70013258 -FRA Addendum P01

DATE:	11 June 2024	CONFIDENTIALITY:	Public
SUBJECT:	WSP Response to LLFA comments		
PROJECT:	Land East of Westergate, Aldingbourne. Ref 70013258	AUTHOR:	Julien Blavignac
CHECKED:	Luke Beeching	APPROVED:	Luke Beeching

WSP RESPONSE TO LLFA COMMENTS

This addendum has been prepared in response to comments raised in the objection submitted by West Sussex County Council Lead Local Flood Authority (LLFA) dated 3rd of April 2024 in relation to the Flood Risk Assessment and Drainage Strategy issued as part of the outline planning application AL/11/24/OUT - Land East of Westergate, Westergate.

PROPOSED HARD STANDING & GREENFIELD AREAS

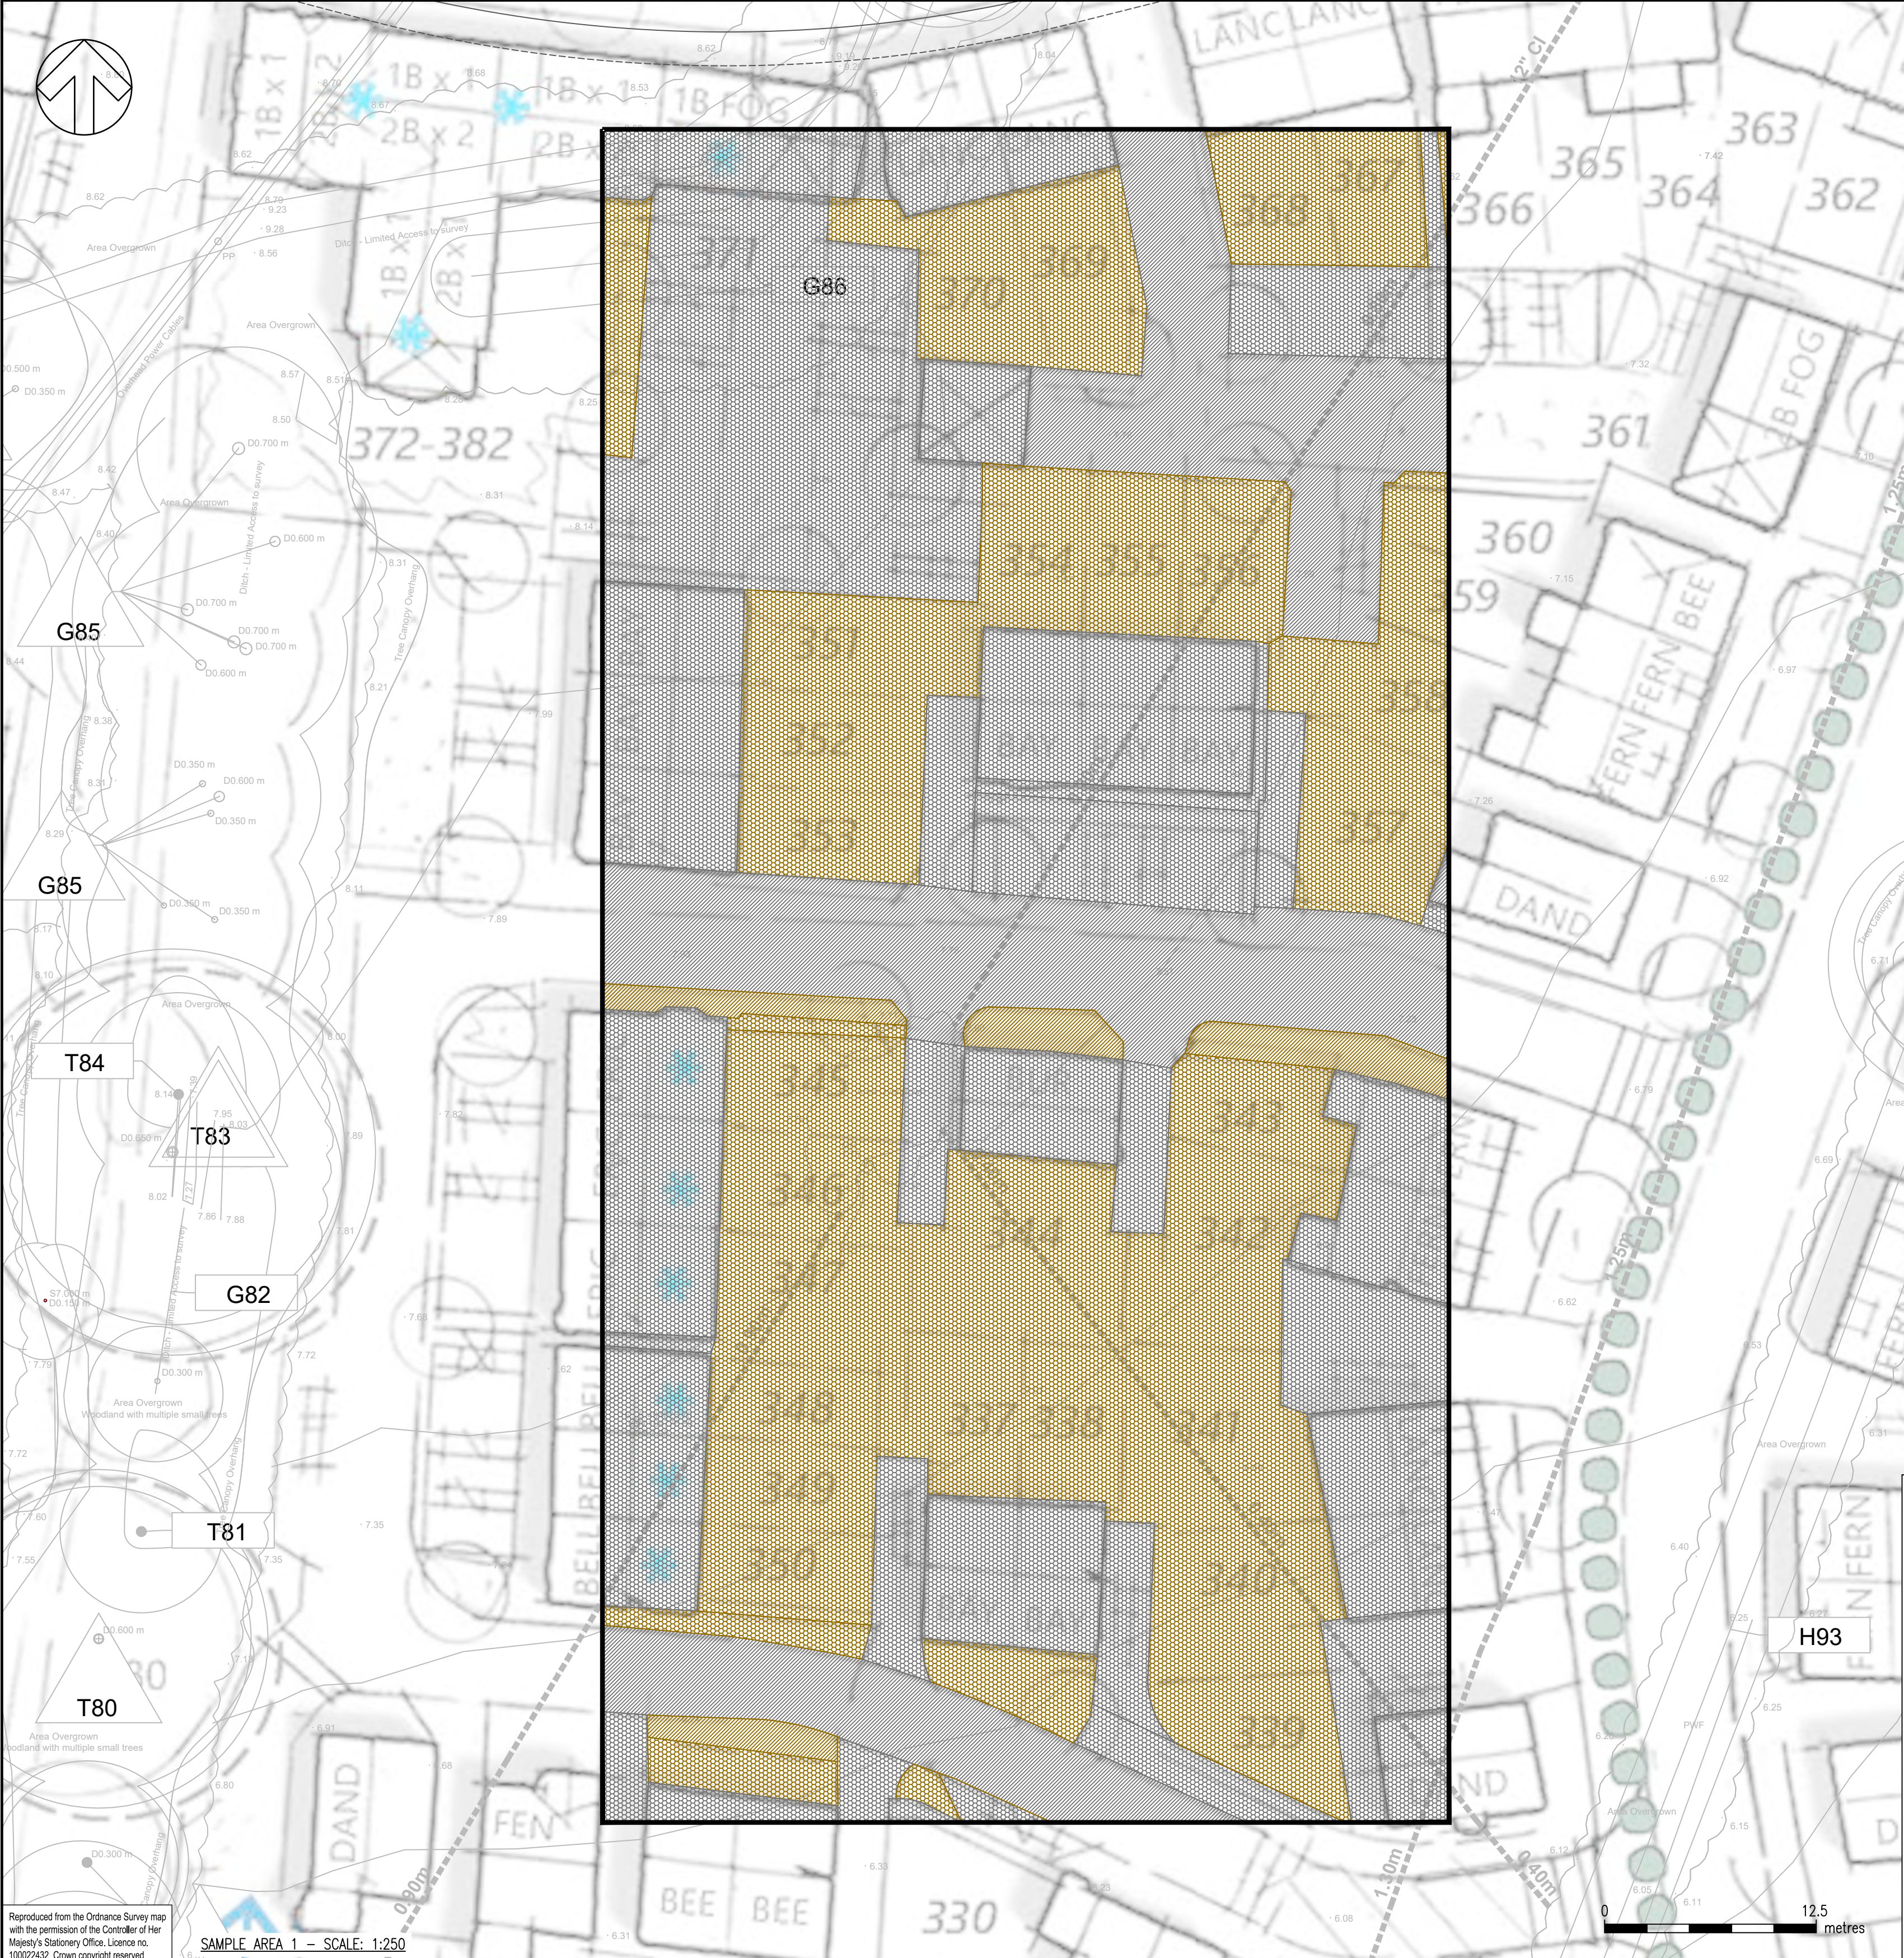
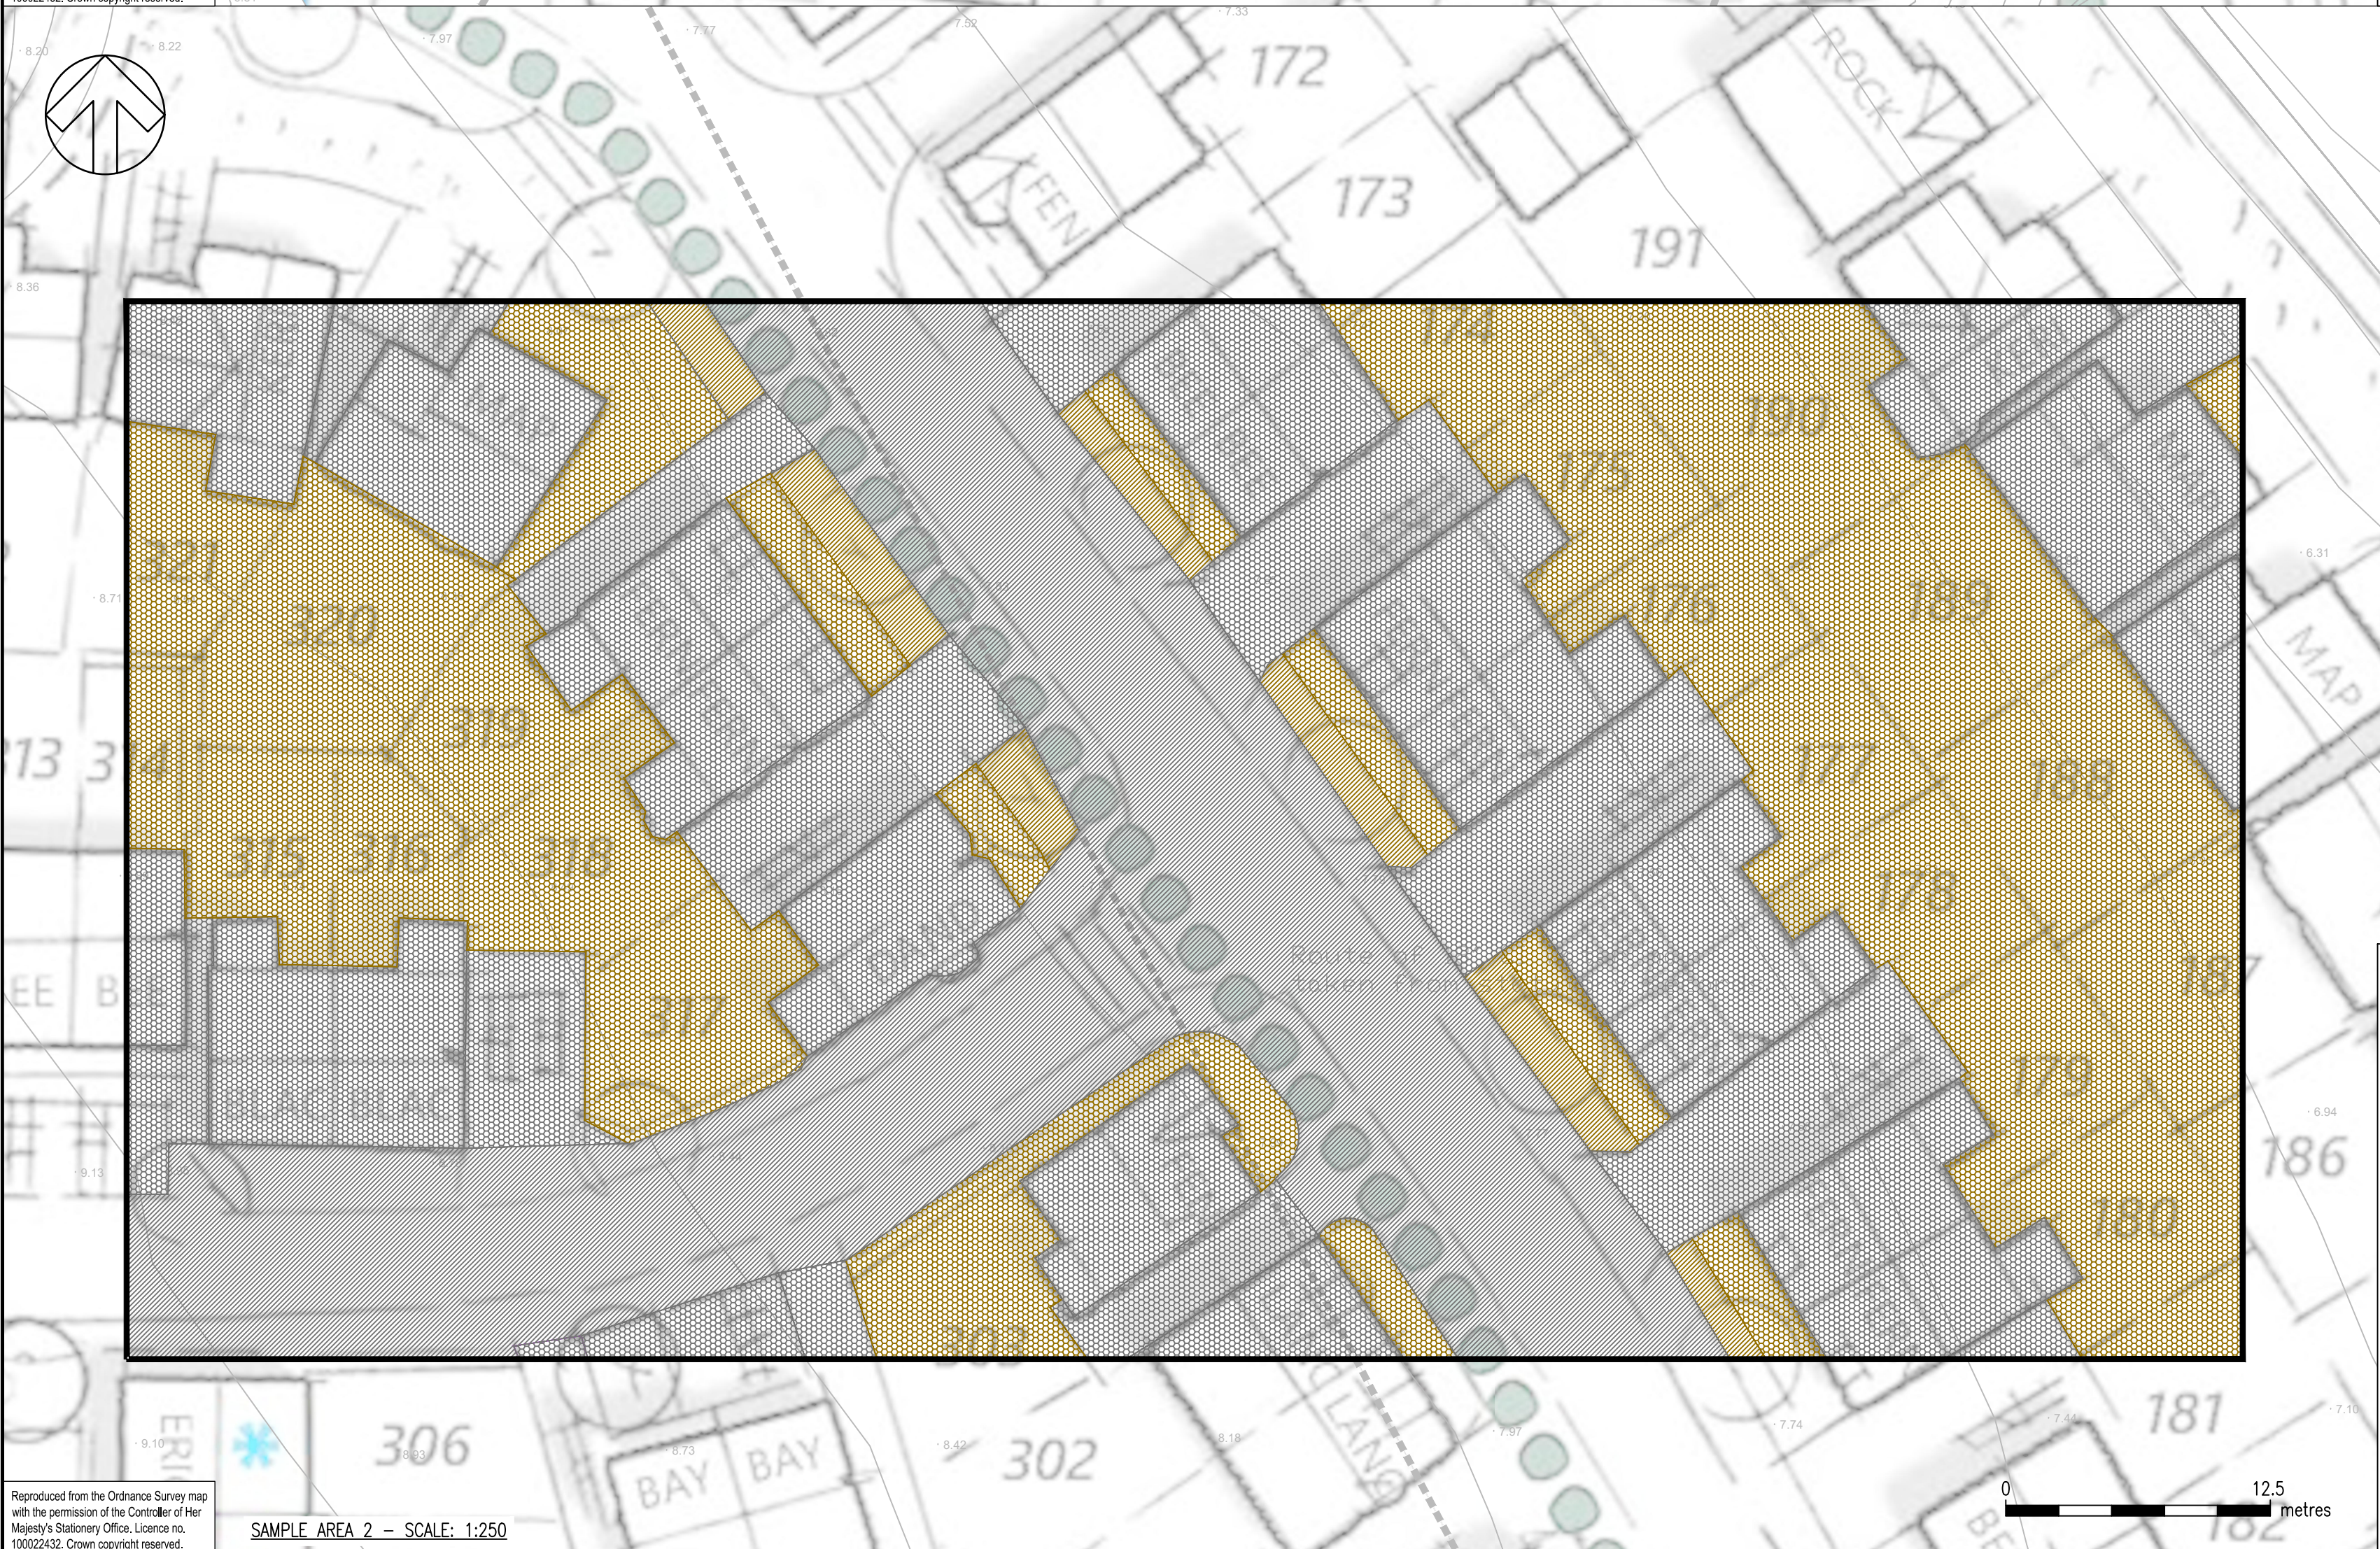
2.Outline drainage modelling calculations should be resubmitted and demonstrate how 10% urban creep has been included in the volume of SuDS storage required.

In order to make an assessment of the property curtilage and the relative split of permeable and impermeable areas in the proposed development, two areas of the illustrative layout have been sampled. This is summarised on WSP Sketch LAW-WSP-XX-XX-C-SK-004, included in Appendix B.

The assessment identifies that the hard standing associated with property curtilages (Proposed Hard Standing Area – Private) represent 38% to 41% of the samples taken in the mid and high dwelling density areas of the development. The higher value of 41% has been used in the subsequent assessments and calculations.
